SPR EA1N and EA2 PROJECTS

DEADLINE 7 - SASES COMMENTS ON NATIONAL GRID (NGET, NGESO & NGV) RESPONSES TO ExQs2

Interested Party: SASES

Date: 4 March 2021

Drawing file: published-documents / EN010078-001386-6.2.29.13 EA2 ES Figure 29.13 Viewpoint 1 PRoW near Friston House (with National Grid AIS Substation).pdf

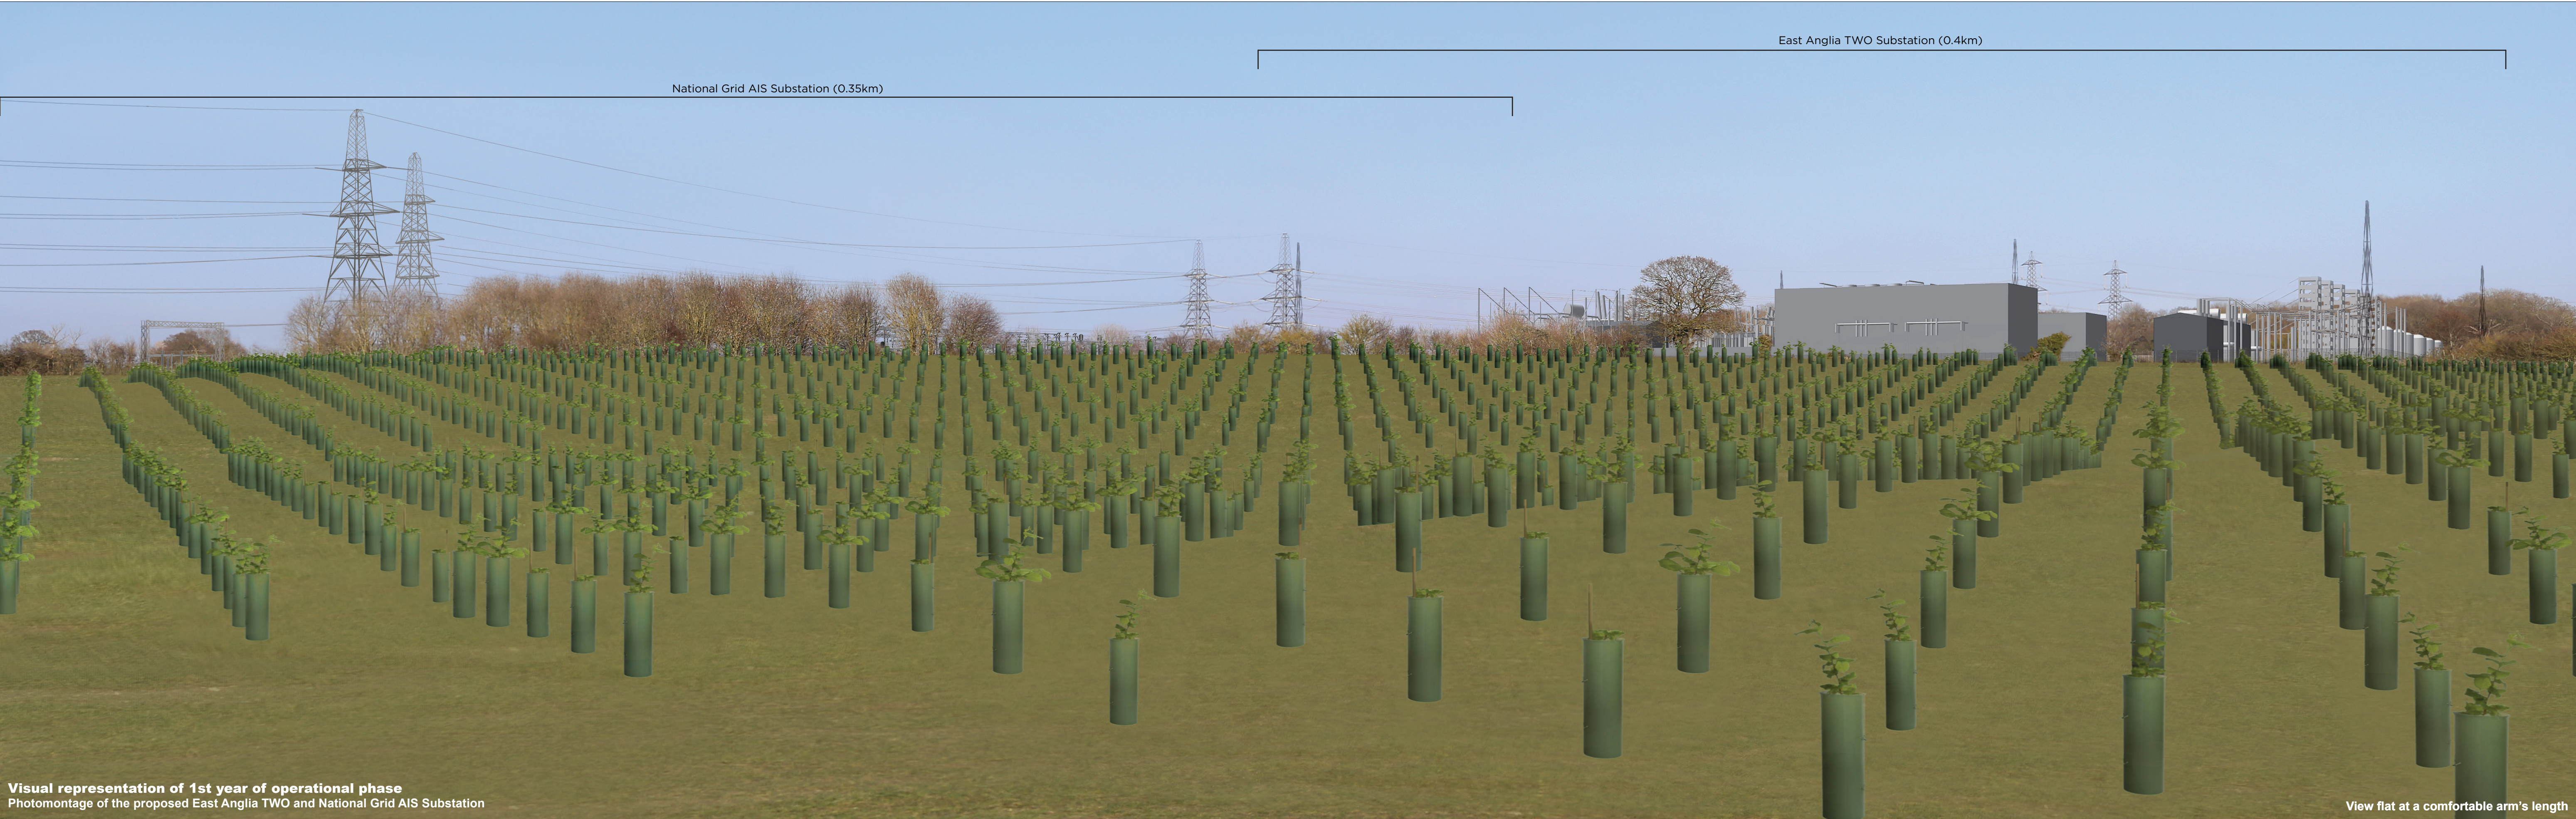
2.10.6	Proposed National Grid substation	<p>SASES has been unable to locate any detailed design information for the proposed NGET substation (either AIS or GIS) including plans and/or elevations (with cross-sections) and without this information no adequate assessment can be made of visual and other impacts of the proposals. This is unacceptable at such a late stage in the Examination process.</p> <p>With regard to the AIS versus GIS choice there is a clear inconsistency between the Applicant’s commitment to the use of GIS in its substations regardless of SF6 issues, and NGET’s lack of a clear decision, which is all the harder to understand given the potential availability of adequate land area for an AIS version of the NGET substation.</p> <p>NGET stated at CAH2 (page 10 of written summary of oral case) that “AIS technology is easier to operate, maintain and repair and as such has lower operational costs which is important in meeting its s.9 duties”. It is also understood from generally available literature that AIS switchgear</p>

Drawing file: published-documents / EN010078-001408-6.2.29.33 EA2 ES Figure 29.33 Viewpoint 1 PRoW near Friston House (with National Grid GIS Substation).pdf

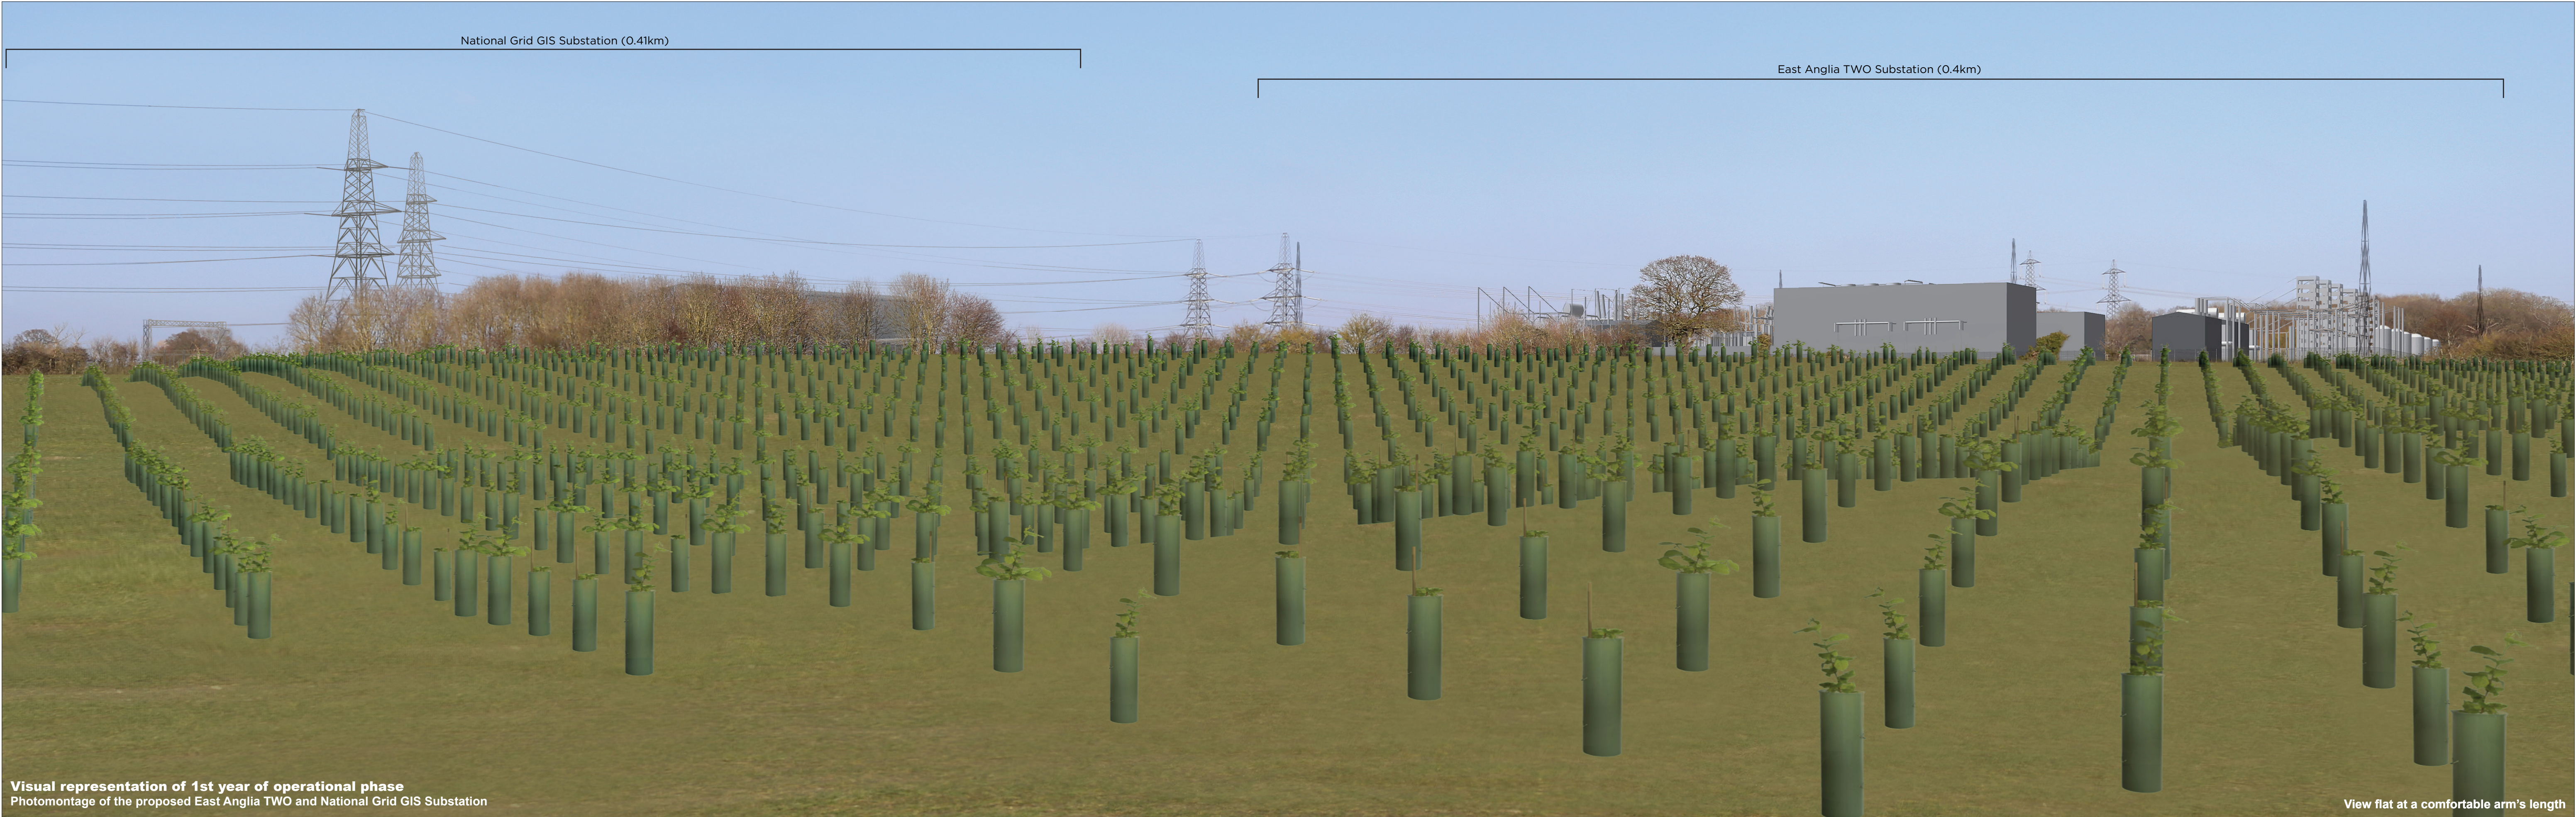
<p>has lower installation costs than the equivalent GIS equipment. Even if a more environmentally friendly alternative to SF6 were to become available in the requisite timescale there is no evidence that such GIS equipment would be more economic to construct or maintain than current GIS equipment, indeed the opposite seems more likely. SASES view, therefore, is that given available information the proposal that a GIS option be retained by NGET is unjustified and unreasonable given the possibility of adequate land availability for an AIS solution.</p> <p>SASES reiterates that it is not reasonable for NGET to fail to establish a clear position now on the AIS versus GIS choice and that this is essential to bring certainty to the Applicant’s proposals in a number of respects.</p>
National Grid ESO (“NGESO”)		
No responses provided		
National Grid Ventures (“NGV”)
